From: Laura Gibbons <Laura.Gibbons@arun.gov.uk>
Sent: 16 March 2021 15:39
To: Planning.Responses <Planning.Responses@arun.gov.uk>
Cc: Raymond Cole <Raymond.Cole@arun.gov.uk>
Subject: RE: Planning Consultation on: F/4/20/OUT

Engineers Comments Regarding Surface Water Drainage

Application No: F/4/20/OUT
Registered: 25th February 2020
Site Address: Land at Ford Airfield Ford
Grid Reference: 499204 102967
Category: Plan App with EIA
Description of Works: Outline planning application (with all matters reserved except for access) for the development of up to 1,500 dwellings (Use Class C3), 60-bed care home (Use Class C2), up to 9,000 sqm of employment floorspace (Use Classes B1), local centre of up to 2,350 sqm including up to 900 sqm retail / commercial (Use Classes A1-A5) and 1,450 sqm community / leisure floorspace (Use Classes D1-D2), land for a two-form entry primary school (Use Class D1), public open space, allotments, new sports pitches and associated facilities, drainage, parking and associated access, infrastructure, landscape, ancillary and site preparation works, including demolition of existing buildings and part removal of existing runway hardstanding. This application aff

FIGURE 23. LANDSCAPE APPROACH DIAGRAM

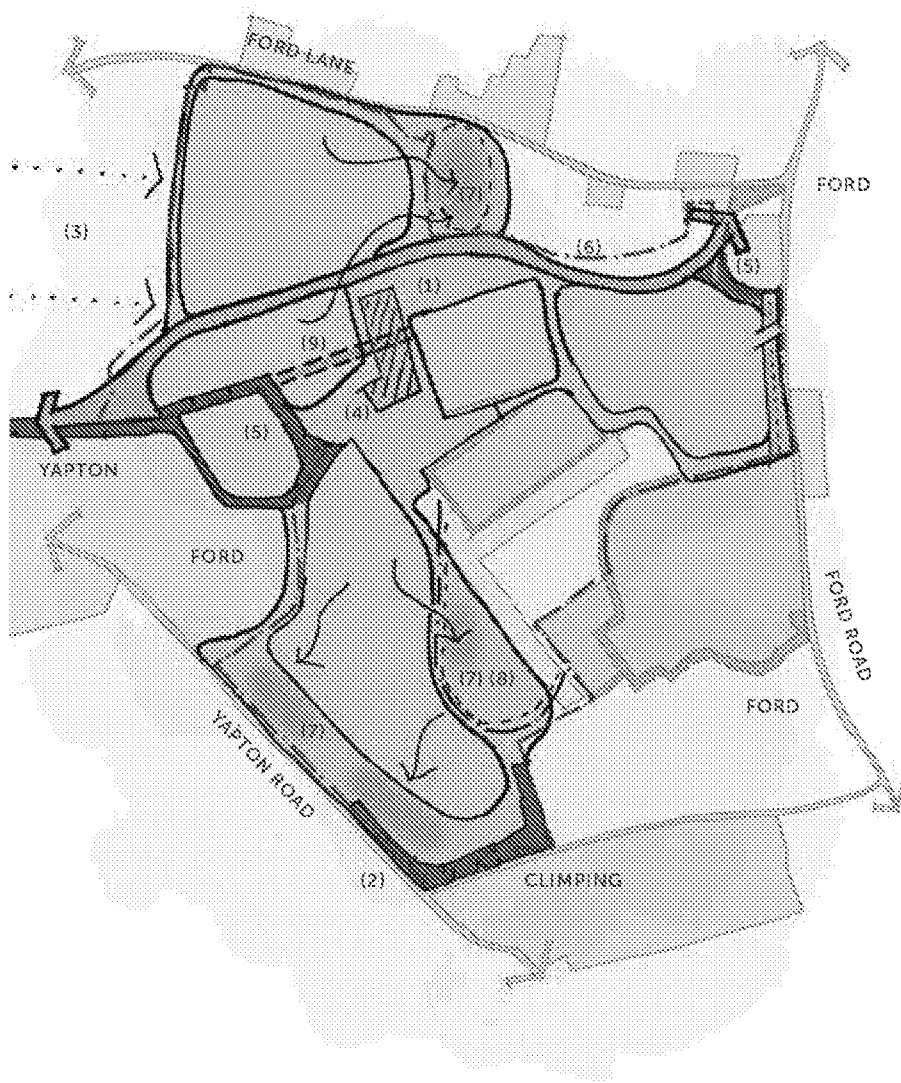
The information submitted does not address our comments from 08/04/20 or 13/01/21. For example, the masterplan document states "In the southern area some limited ground remodelling is required due to the current height of the water table and topography. Therefore, we utilised the opportunity to redirect the surface water towards the area that is affected by odour issues, making the most efficient use of this otherwise non developable land". Drainage should not be moved around to fit in to space that cannot be used for housebuilding.

The proposals for attenuation and pumping of this area of the development do not comply with adopted WSCC policy for the management of surface water, specifically policy 3- mimic natural flows and drainage flow paths. No evidence has been submitted to show why compliance with this policy requirement cannot be achieved. The natural catchment appears to indicate this area should drain toward the watercourses under Yapton Road. We do not support drainage proposals which do not follow existing catchments or look to utilise pumping.
